**Re: Opus Transport Apartments -FINAL  
Traffic Impact Study (M15D023H)**  
Engineer's Stamp 8-2-24  
Via email jroberts@tierrawestllc.com

The subject Traffic Impact Study (Study) received on August 15, 2024, has been reviewed and is approved by the City of Albuquerque Planning Development Transportation Section.

Figure 4: Proposed Striping and Intersection Mitigation

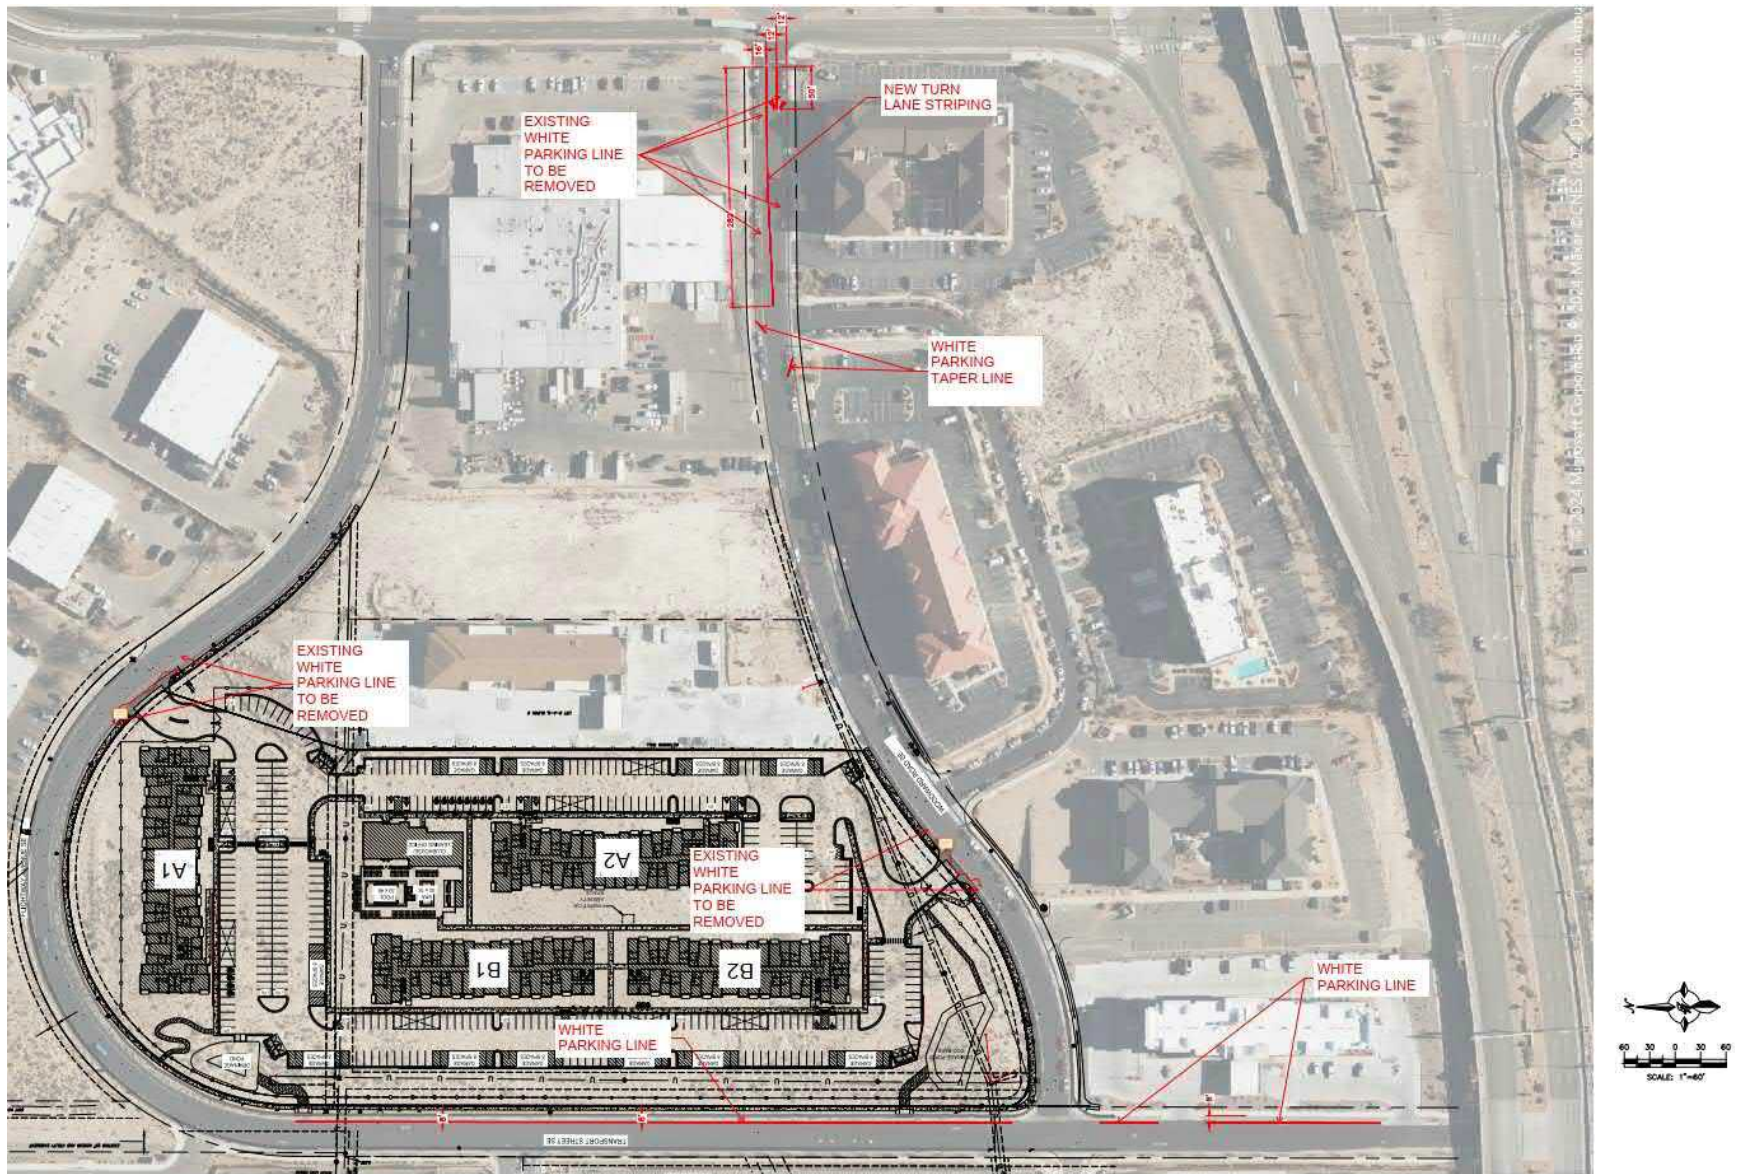
Required infrastructure improvements per the Study include pavement markings as shown on Figure 4, p. XV.
